# The Commons at Falcon Field

## Traffic Impact Study

JUNE 23, 2023

RE: The Commons at Falcon Field  
Preliminary Plan  
El Paso County, CO  
Traffic Impact Study  
LSC #S234220

Sight Distance Analysis Retail Row/Gryfalcon

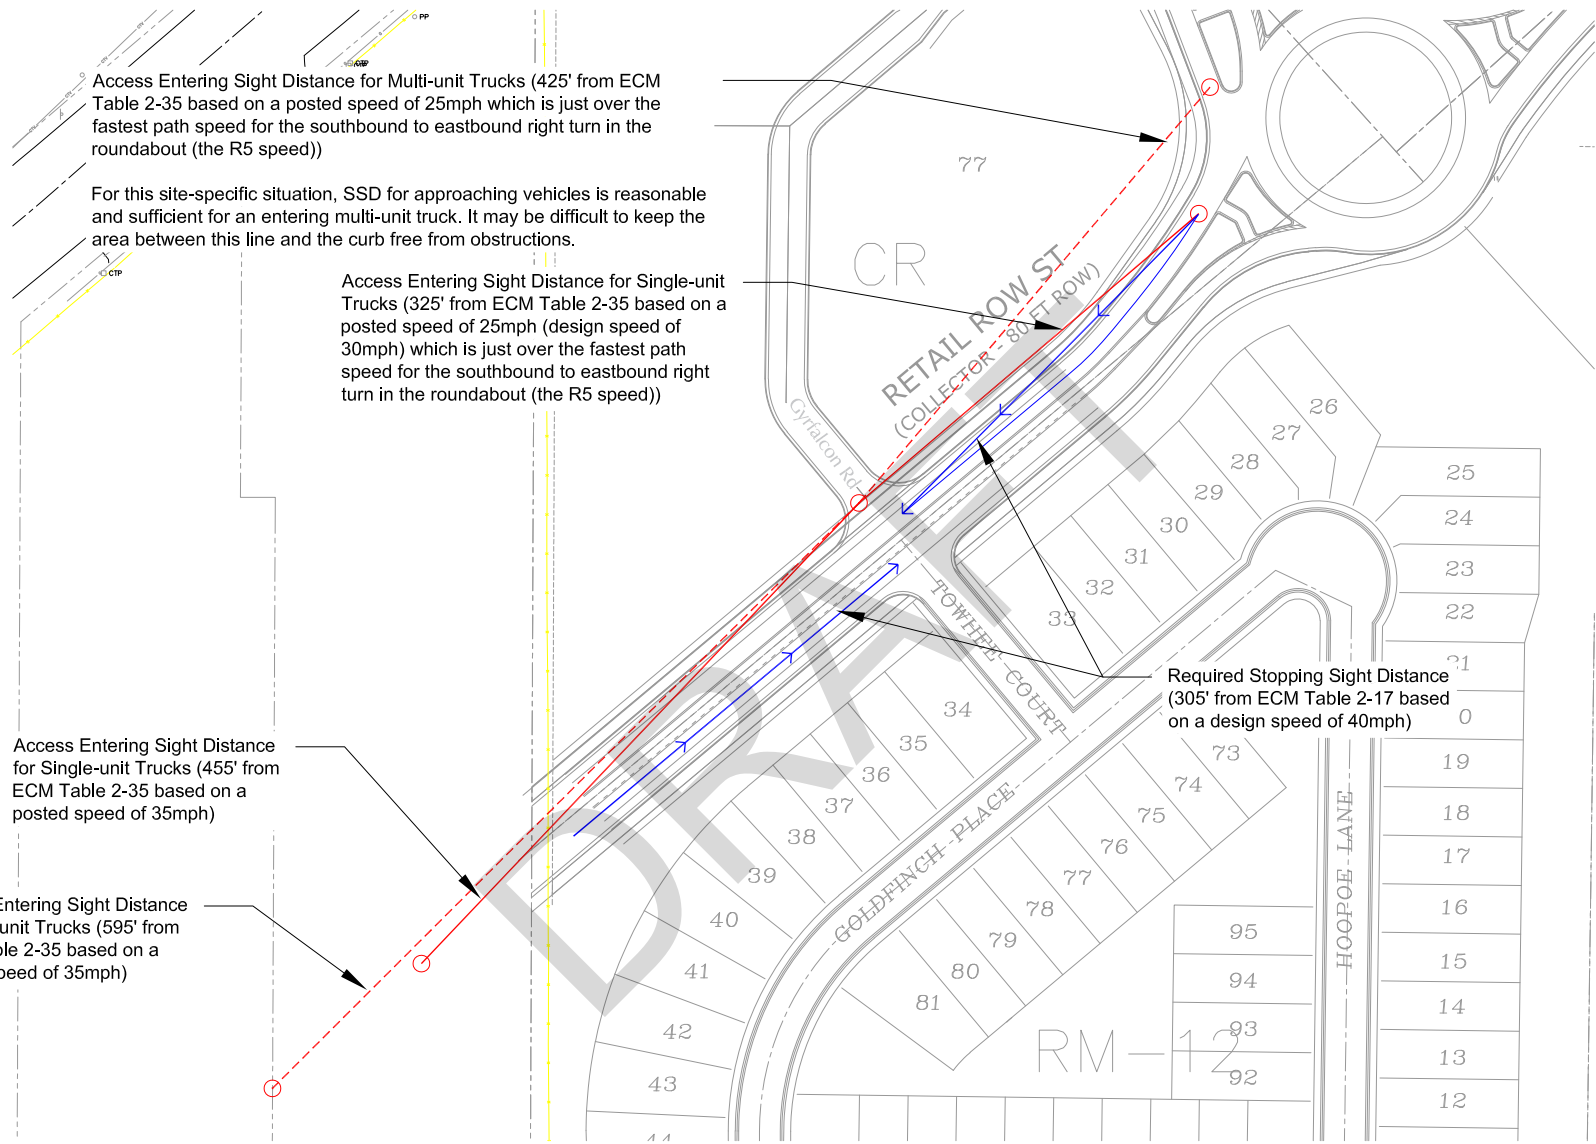
Comments on the preliminary plan have been provided regarding the private roads and the proposed cross section. Due to the volume of traffic and lots being accessed from these private road the Sight distance criteria for roadways as opposed to driveways should be used on the easterly access. Please revise the sight distance analysis accordingly. Additionally, recommendations as to the classification & cross section of the private roadway shall be provided.

please revise as it  
was indicated that  
only the east is  
analyzed due to the  
restricted  
movements.
